Council Ref: Cranbrook School (Trim Folder: SC4477 Ref: 18/154261)
Planning & Development Division

2 October 2018

Application Number SSD 17_8812
Proposal name Cranbrook School Redevelopment (Senior School)
Address 5 Victoria Road, Bellevue Hill

Figure 1 - Location of Bicycle Parking

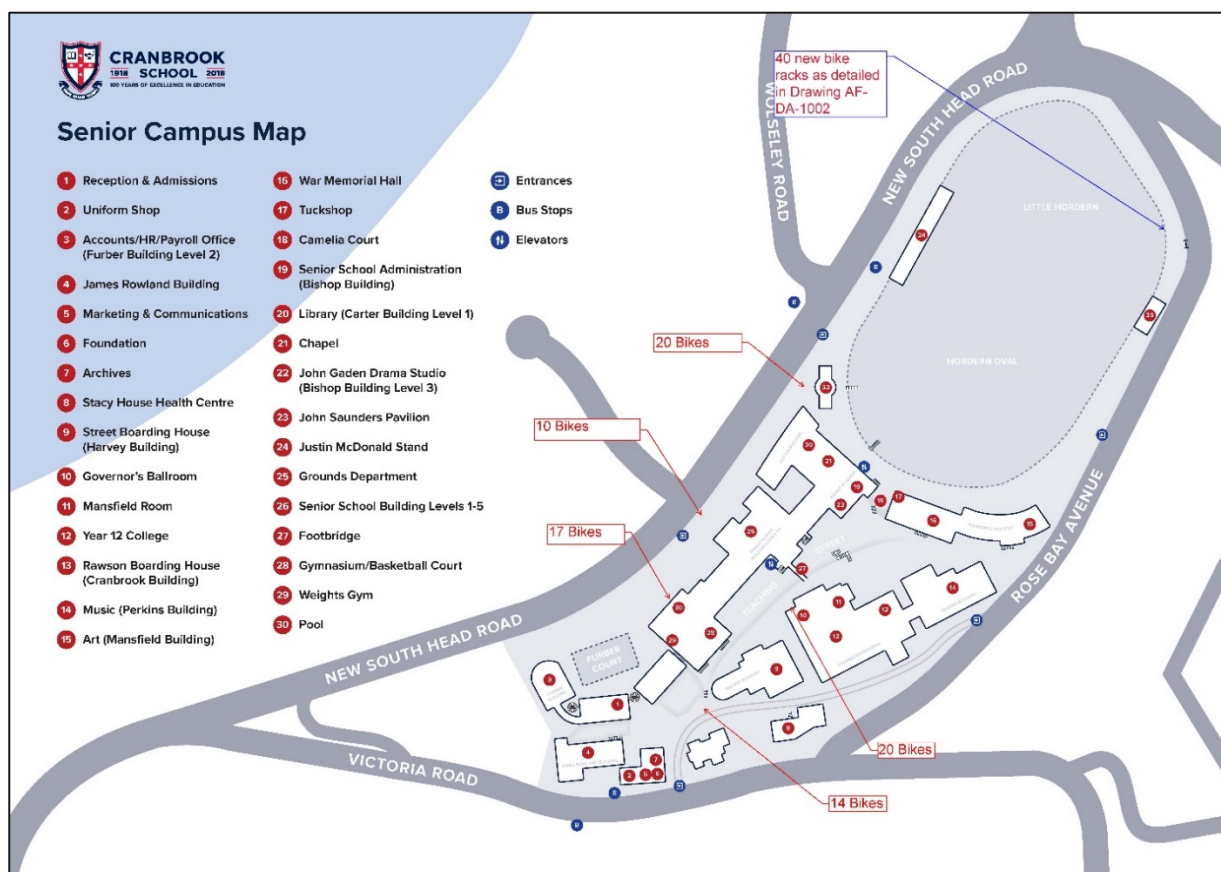
- A *Green Travel Plan* is prepared in accordance with Part E1.12 of *Woollahra DCP 2015* (**Condition 2**).
- Adequate on-site provision shall be made for bicycle storage and facilities in accordance with Part E1.6 of *Woollahra DCP 2015* (**Condition 3**).

On-site bicycle storage and facilities are to be provided in accordance with Part E1.6 of *Woollahra DCP 2015*.
